CITY OF ALBUQUERQUE

April 17, 2012

**Re: Pino Dam Rough Grading
Grading Plan
Engineer's Stamp Dated 5-19-11 (E22/D022)**

Bohannon & Huston Courtney 1 7500 Jefferson St. NE Albuquerque, NM 87109-4335 ENGINEERING • SPATIAL DATA • ADVANCED TECHNOLOGIES	
ALBUQUERQUE METROPOLITAN ARROYO FLOOD CONTROL AUTHORITY PINO DAM ROUGH GRADING	
GRADING PLAN	
DRAWING NO.	MAP NO. E-22-Z
SHEET 4	OF 4

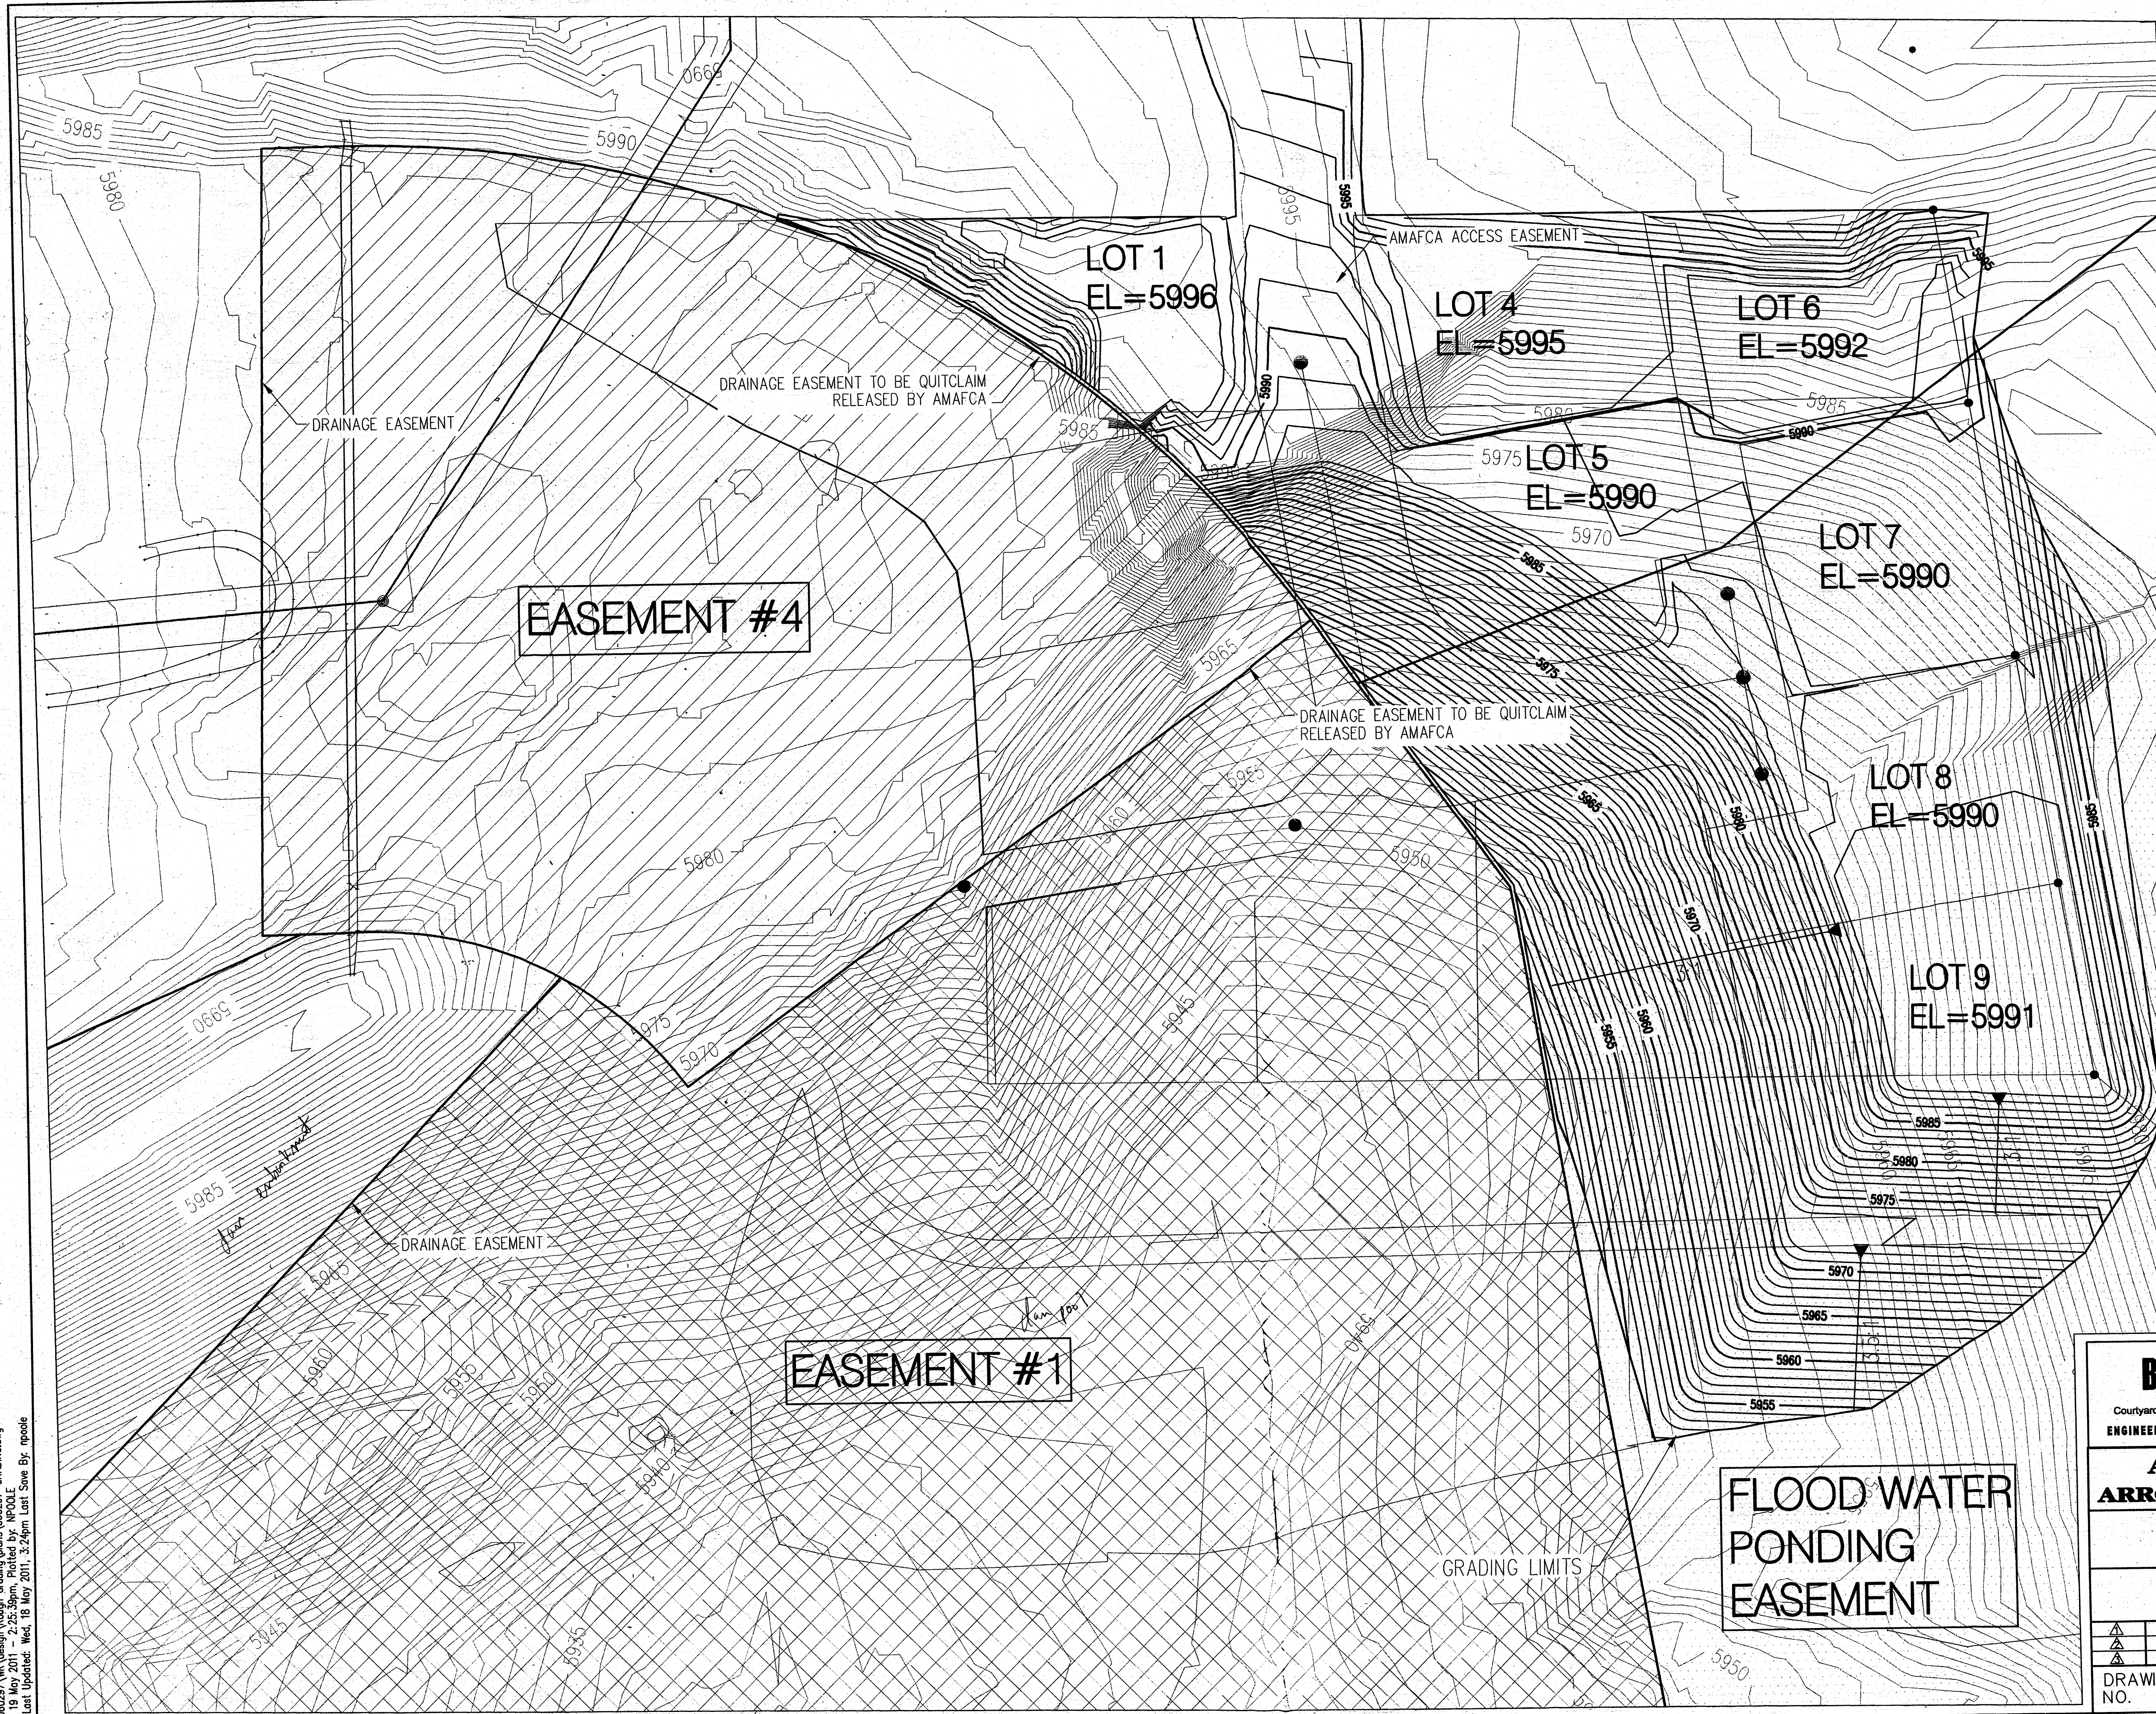
- Preliminary plat approval from the Development Review Board is required.
- This plan proposes grading on adjacent properties. Provide a written approval from adjacent property owners.
- Provide property lines.
- Provide a written letter of approval from AMAFCA.
- Grading has occurred in a flood plain without an approved Flood Plain Permit. Stop all grading at this time. Removal of any fill brought onto this site may need to be removed if procedures for infill were not followed.
